Subject: B-1 Design Review – 788 Washington Avenue
Written by: Caitlin Cameron, Urban Designer
Date of Review: Thursday, July 5 2018

The project at 788 Washington Avenue was reviewed according to the *City of Portland Design Manual* standards by Caitlin Cameron, Urban Designer, Jean Fraser, Planner, and Matt Grooms, Planner, against the *B1 Commercial Business Zones Standards* (Section (d) of the Design Manual).

BUILDING ELEVATIONS  
**A-2.2**

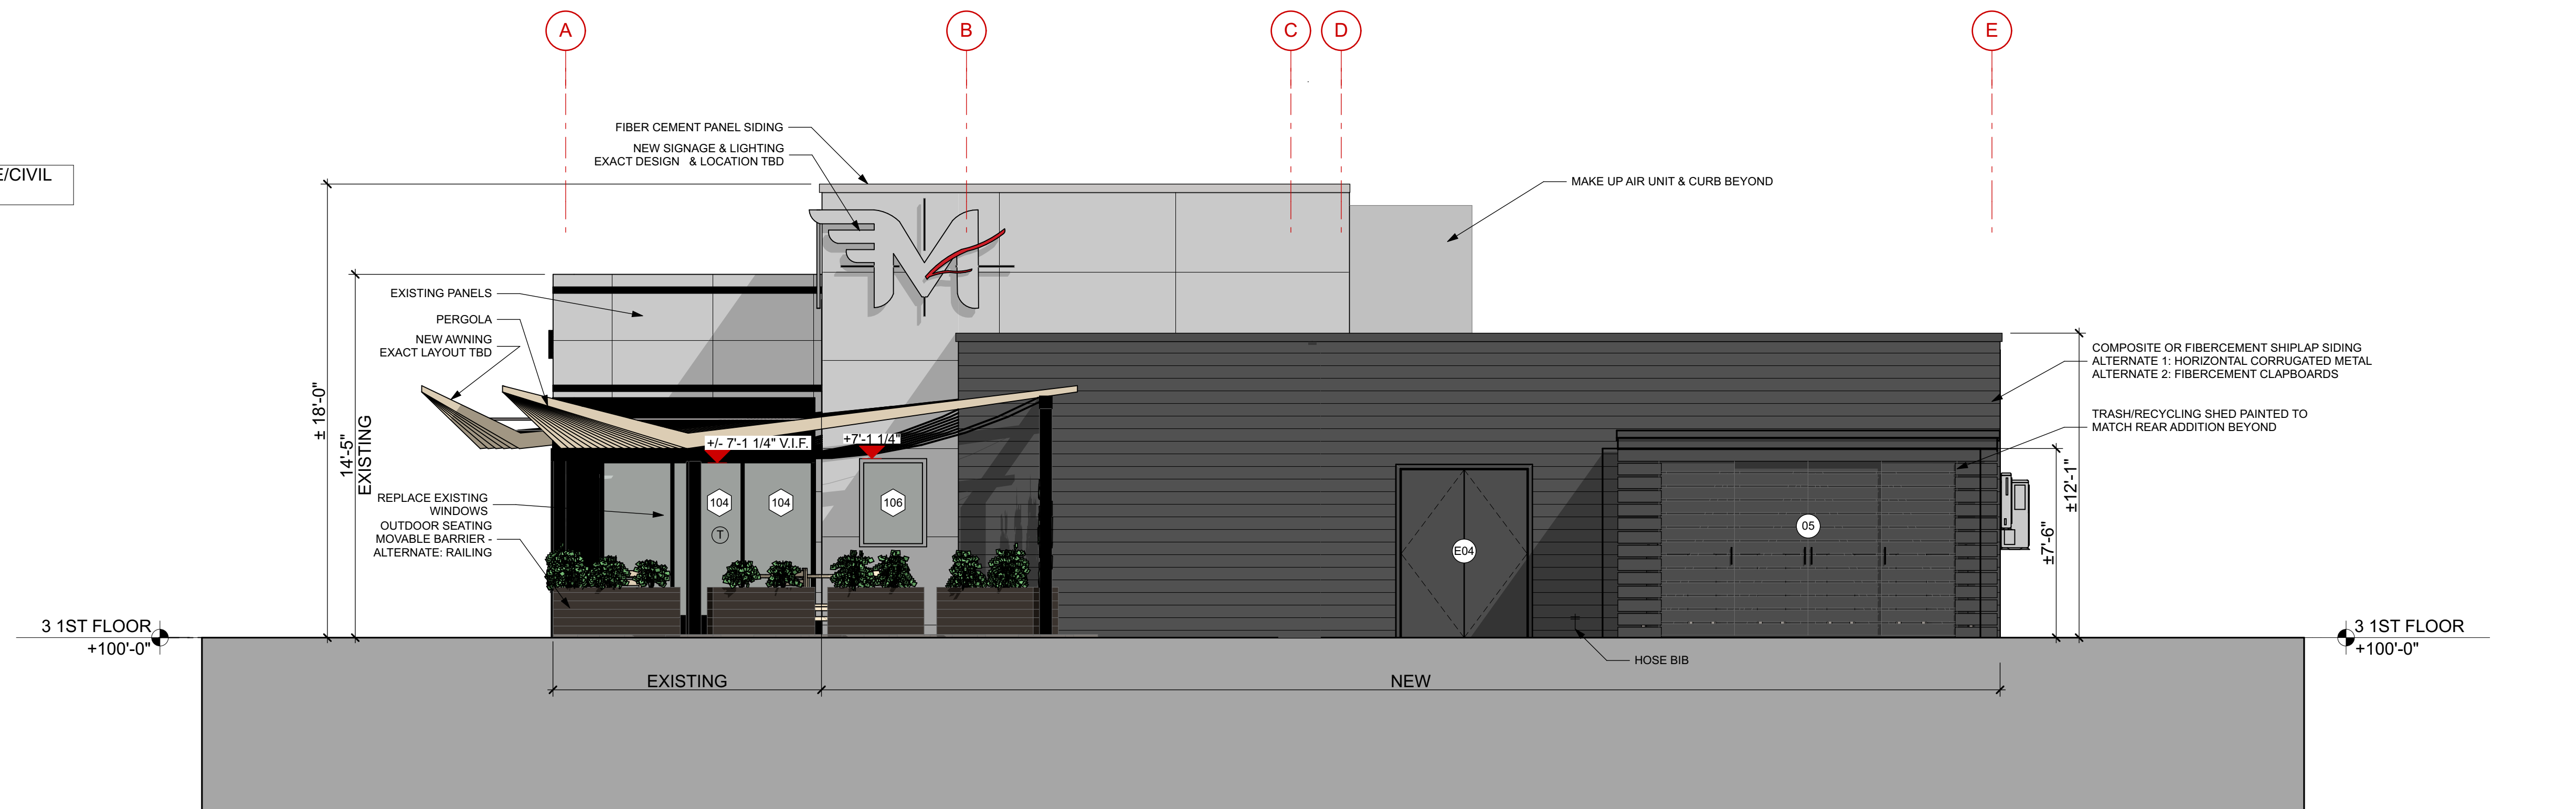
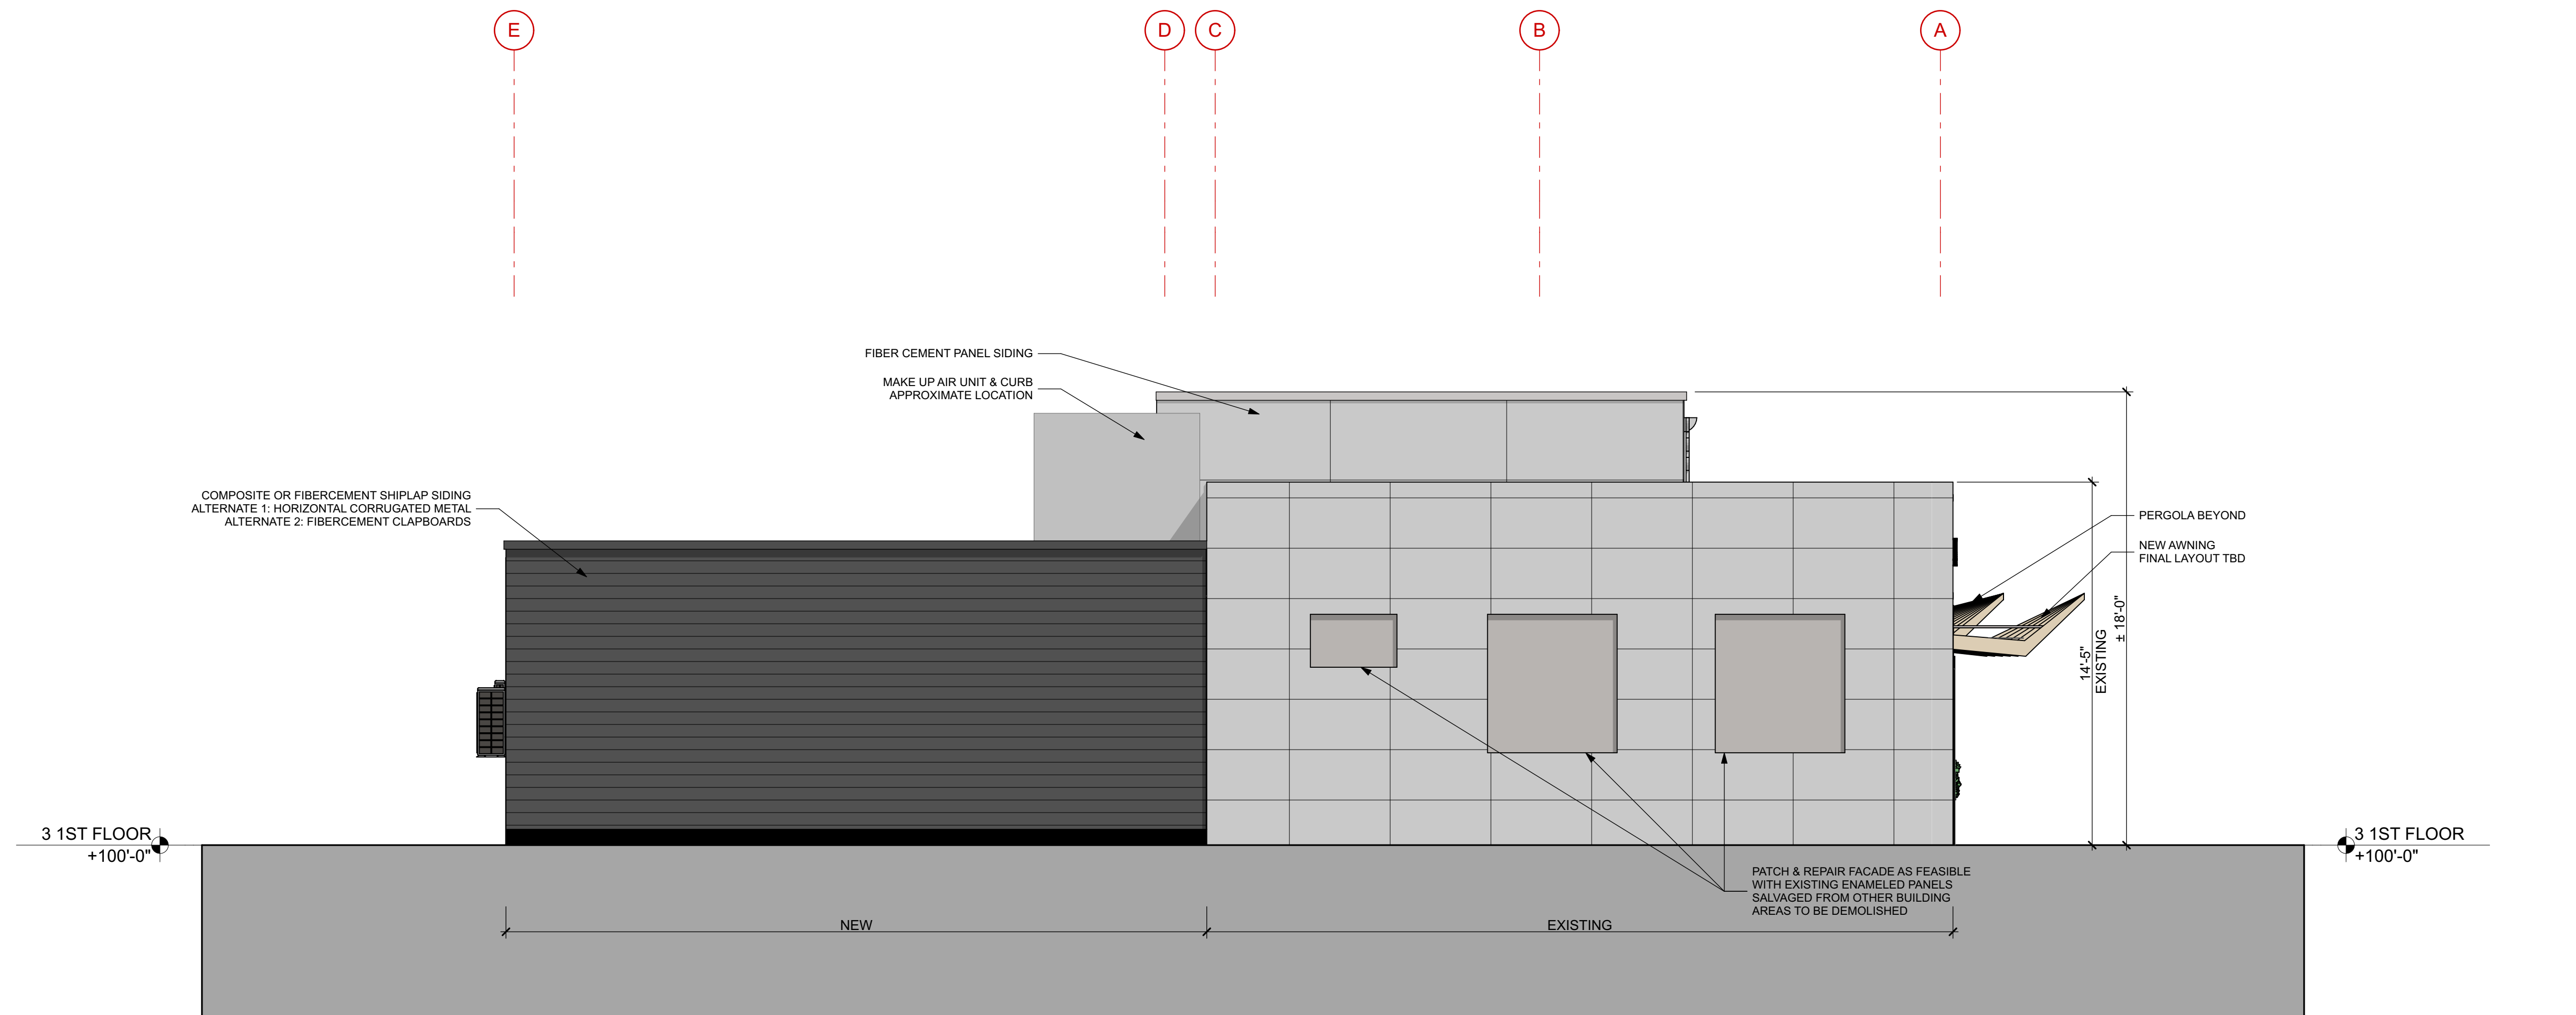
- Canopy design does not read as a welcoming, commercial awning. Consider adjusting the angle, spacing, character to be more hospitable entrance marker.

- Staff question the compatibility of the high contrast of the materials selected – though staff agree the darker material is recessive, the high contrast is out of character with the context, especially the residential context.
 - We consider the contrast to be appropriate to the commercial nature of this intersection and neighborhood business zone where the majority of the buildings are commercial.
 - The white large fibercement panels are to be of a white shade to match the exiting building. In addition any seams or trim between panels will also be of the same color to help unify the existing and the new building. The intention of the dark materials at the rear is for them to recede as pointed out by Staff. Furthermore, the dark color of the rear volume is meant to harmonize with the darker accents proposed for the existing building.

- We consider the awning to be appropriate to the commercial character of both the building and this commercial business zone. However, we're open to fine-tune the awning design to make it more welcoming as recommended. We ask however, that this item be reviewed and finalized during the building permitting process.

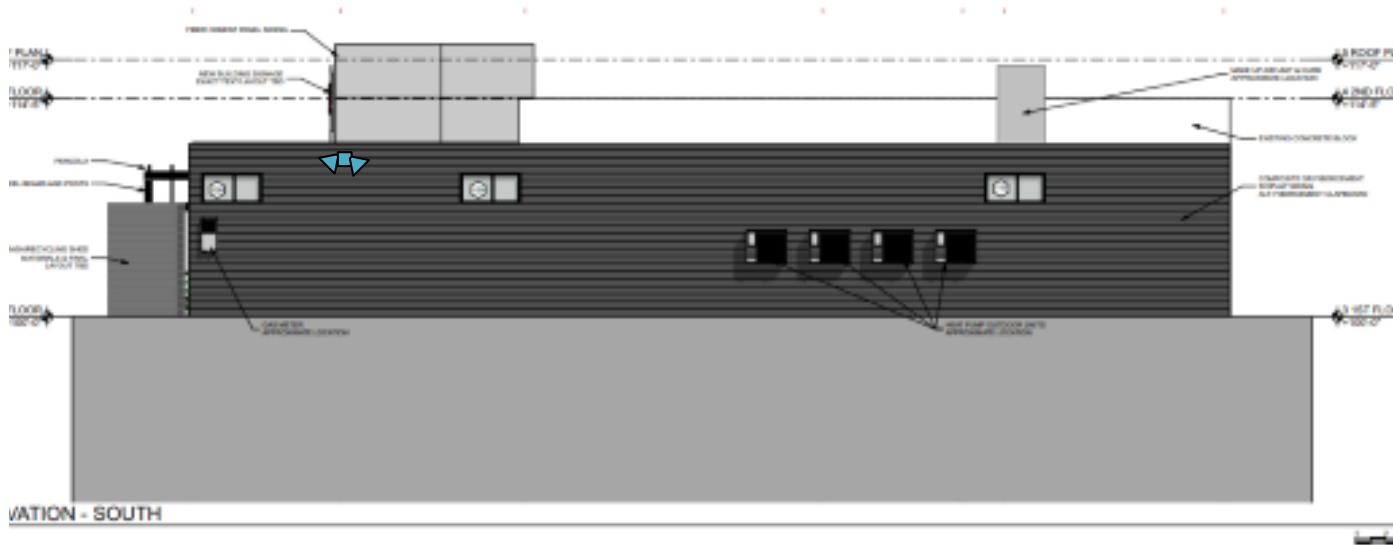
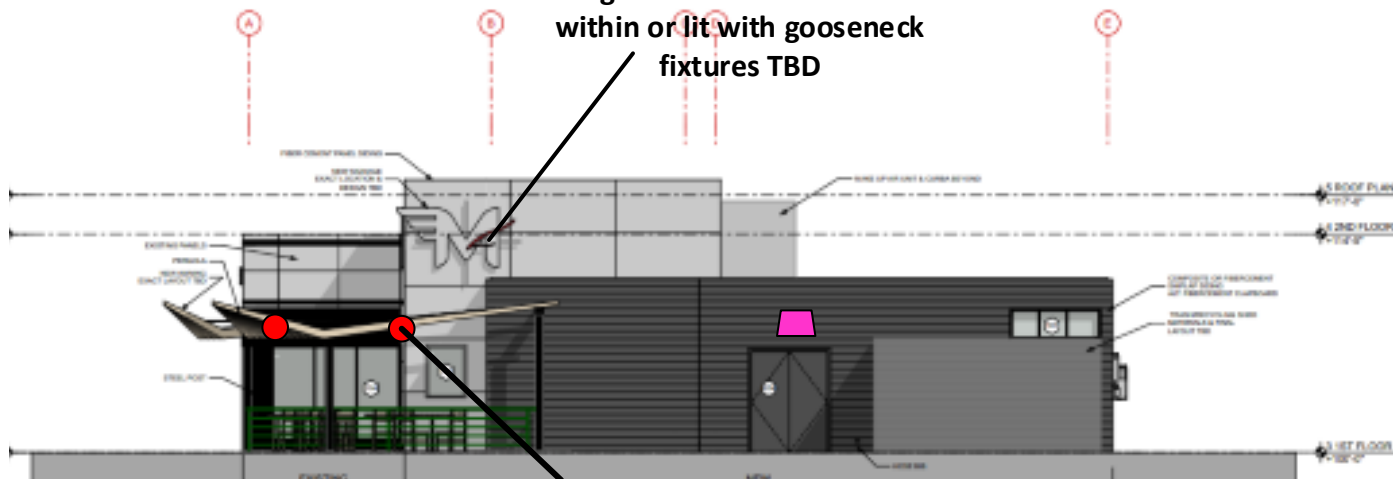
- **Why is a second door provided on this façade? Second door not as recessive as could be**
- legibility concerns.

- The secondary door on the existing building is an existing door to remain. We are proposing to keep this door, as it is an important characteristic of the existing building type formerly a mobile station. We've opted to paint this door to match the siding as well as the taller structure to allow the door to recede to the background. However, we agree that this door could be more recessive.

- We propose removing the lighting wall pack shown on the original front elevation lighting drawing. As this door is not part of the egress path of travel and there will be sufficient ambient lighting from adjacent lights, we anticipate this would be much more effective.

ROOF PLAN

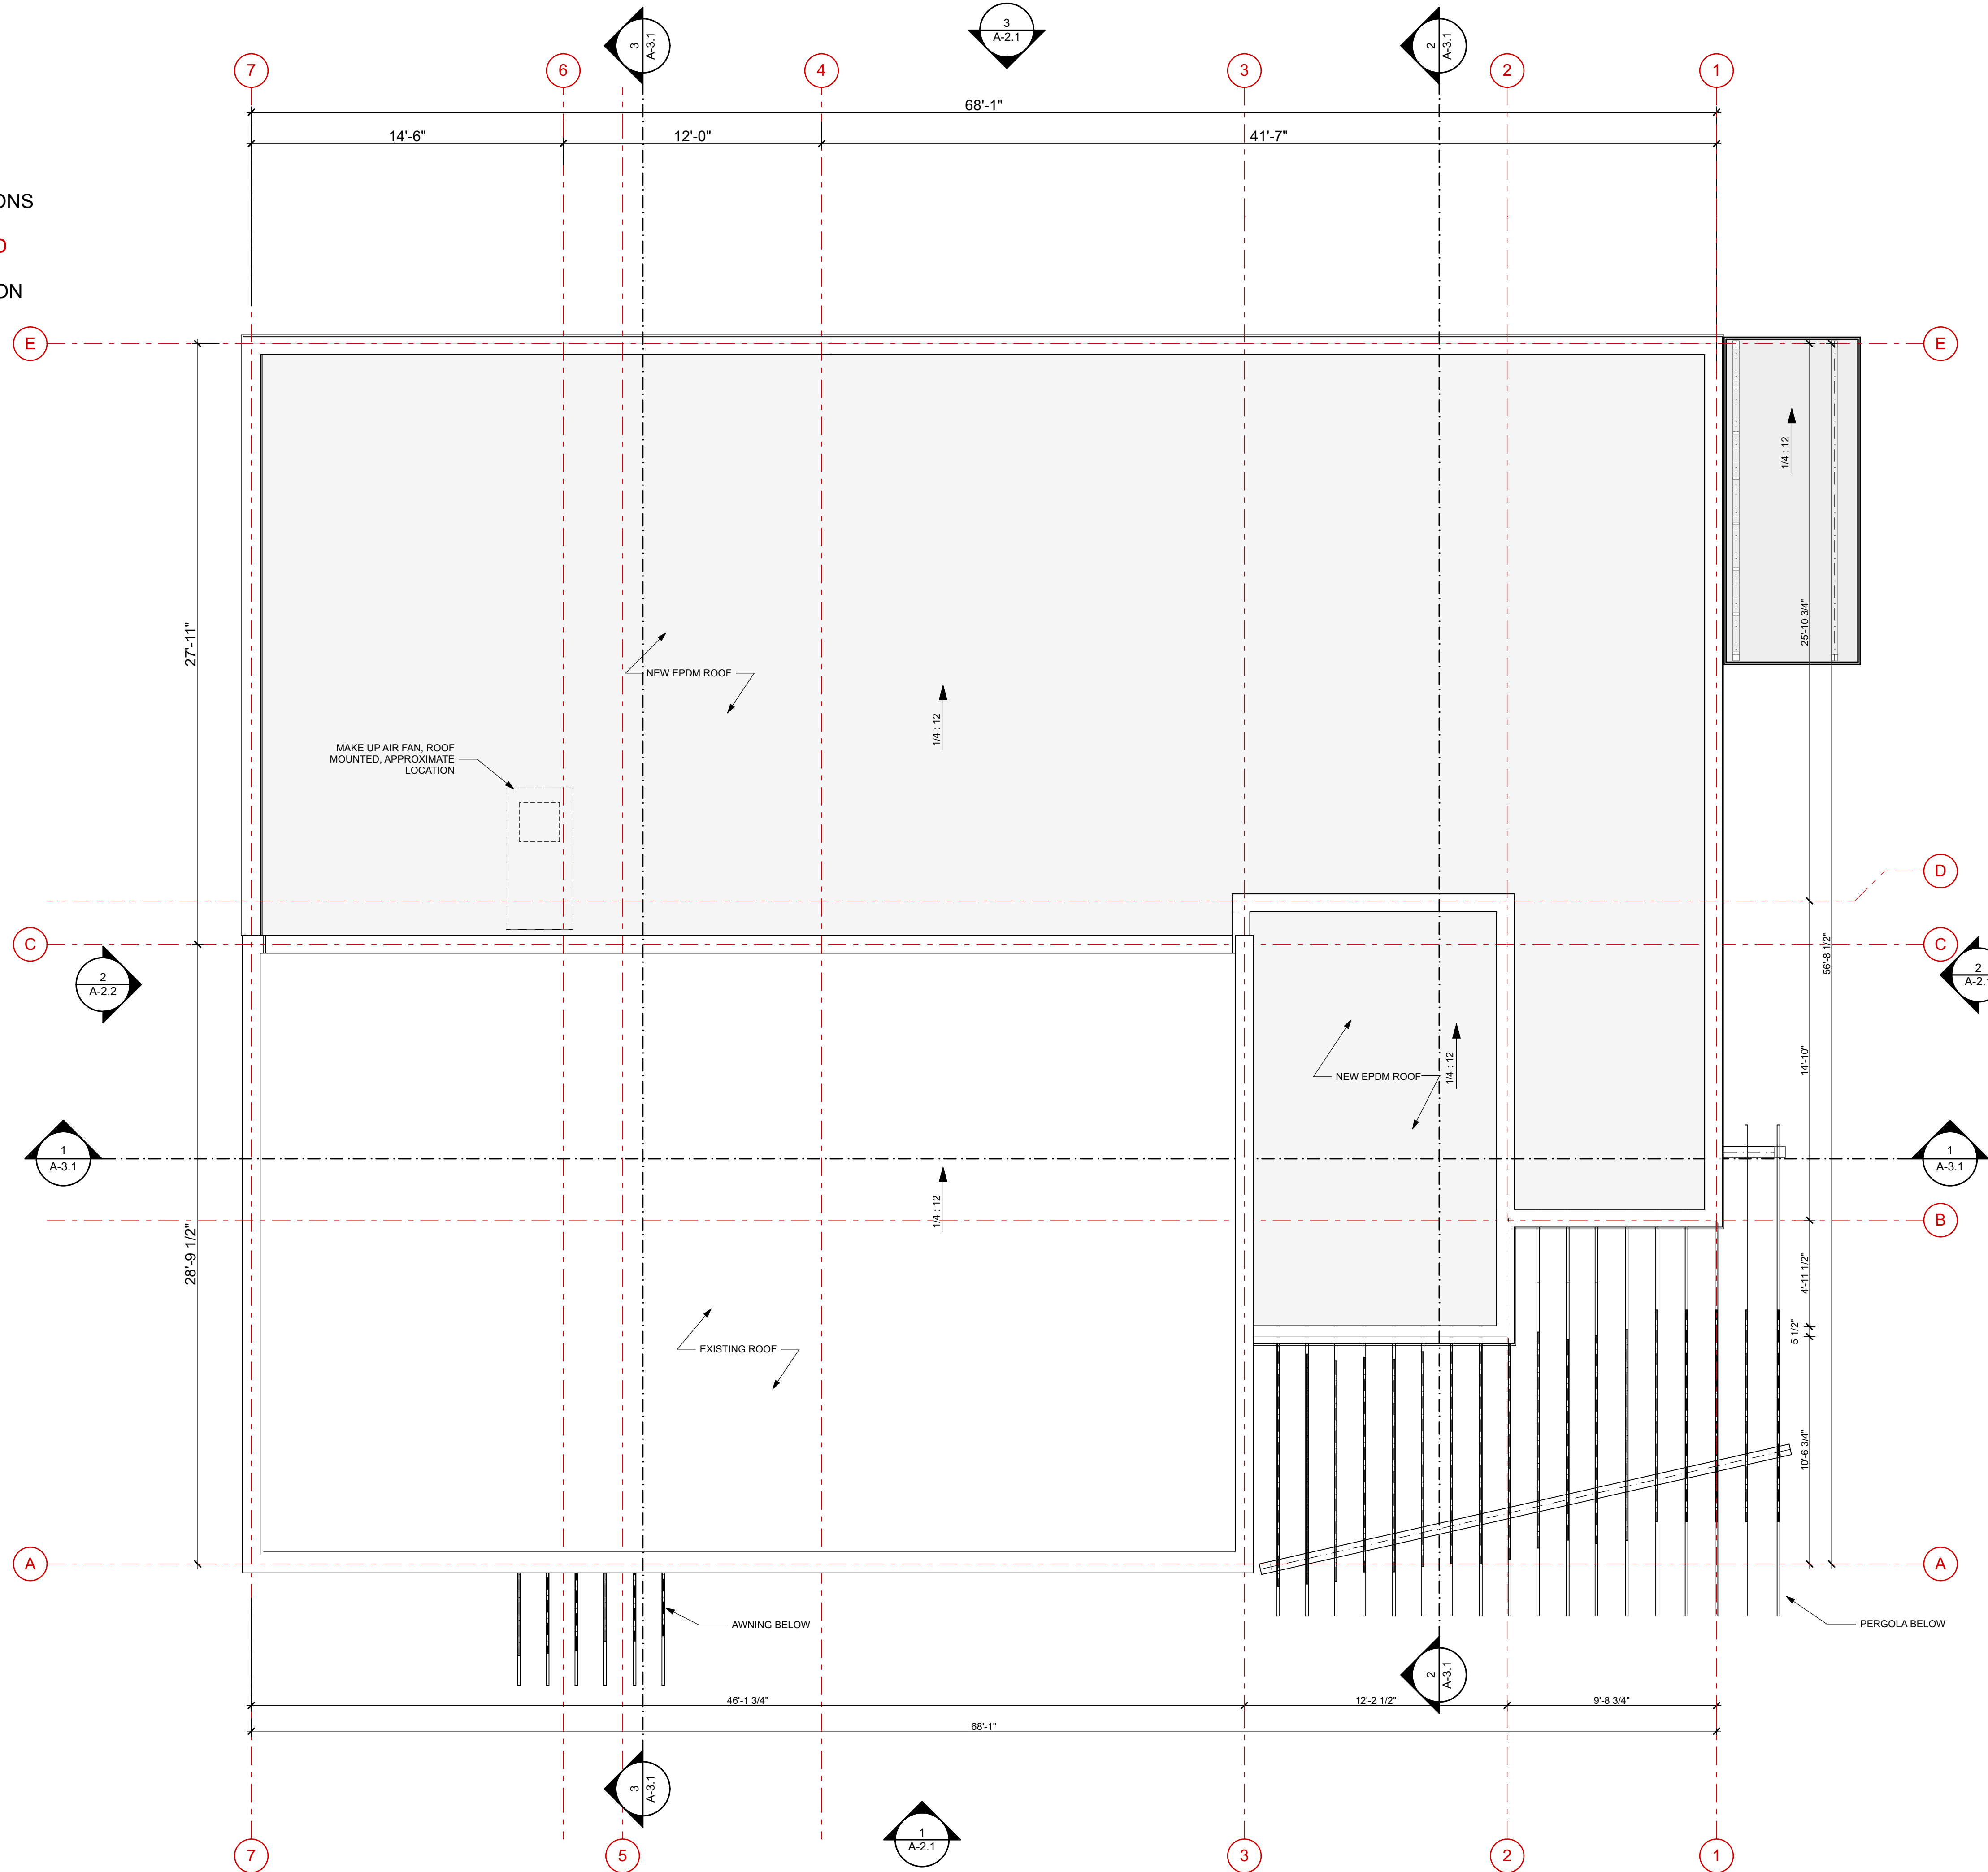
- Could the building height be extended to provide screening of the rooftop mechanicals?
 - The rooftop make-up air unit is in keeping with the commercial nature of the building. Additionally, we've been careful to place it towards the rear of the building to minimize views from the two major intersections. If we were to raise the walls of the rear darker volume, it would cease to recede and would in our opinion become more prominent than the existing structure.
